From: Anna Russell-Smith <anna.russell-smith@montagu-evans.co.uk>
Sent: 25 August 2021 18:15
To: Richard Phillips
Cc: Nadine James
Subject: RE: Northwood & Pinner Cottage Hospital & Northwood Health Centre, Pinner Road - 23658/APP/2021/1296
Attachments: NandP_DSO_amendment_note_25.08.21.pdf

Subject: Northwood & Pinner Cottage Hospital & Northwood Health Centre, Pinner Road - 23658/APP/2021/1296

6.6.4 Block B: Category 3 Units

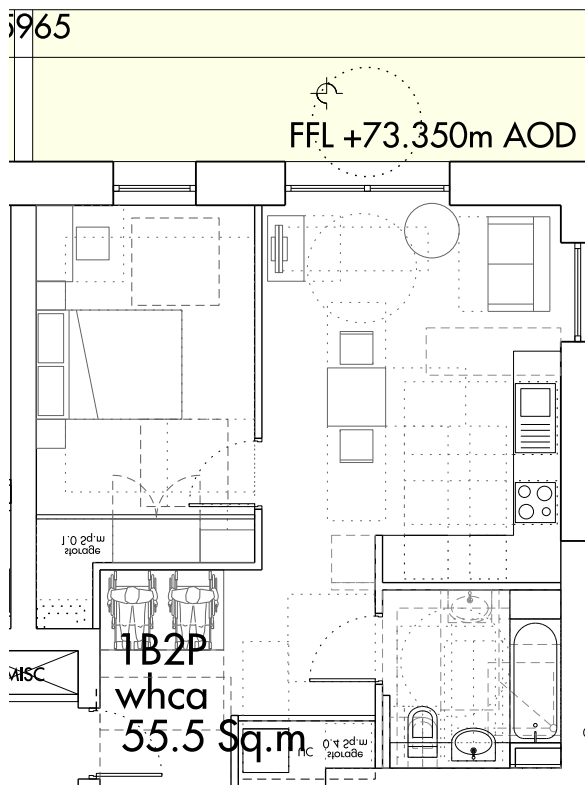
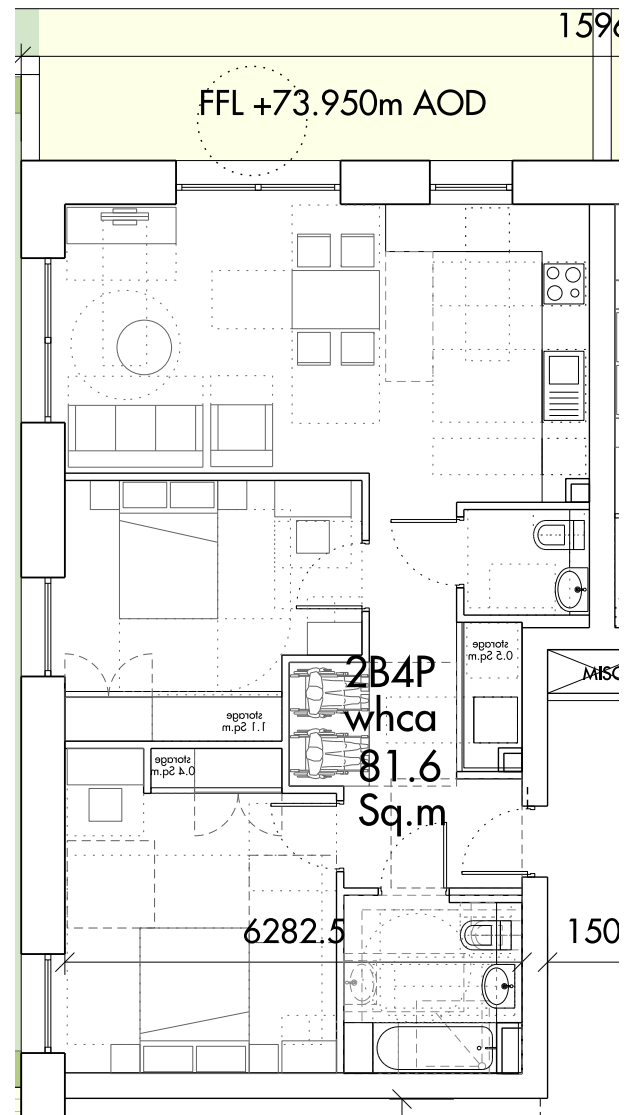
6. Where lift access is necessary to achieve a step free approach to the principal private entrance, all M4(3) units should be served by at least two lifts. It is unclear from the submitted plans where these wheelchair accessible/adaptable units would be located. Further clarity is requested.

7. A floor plan at no less than 1:100 should be submitted for each of the different M4(3) units. All details, to include transfer zones, wheelchair storage area, and other spatial requirements within bedrooms, bathrooms, living and dining areas, should be shown on a separate plan for every different unit type.
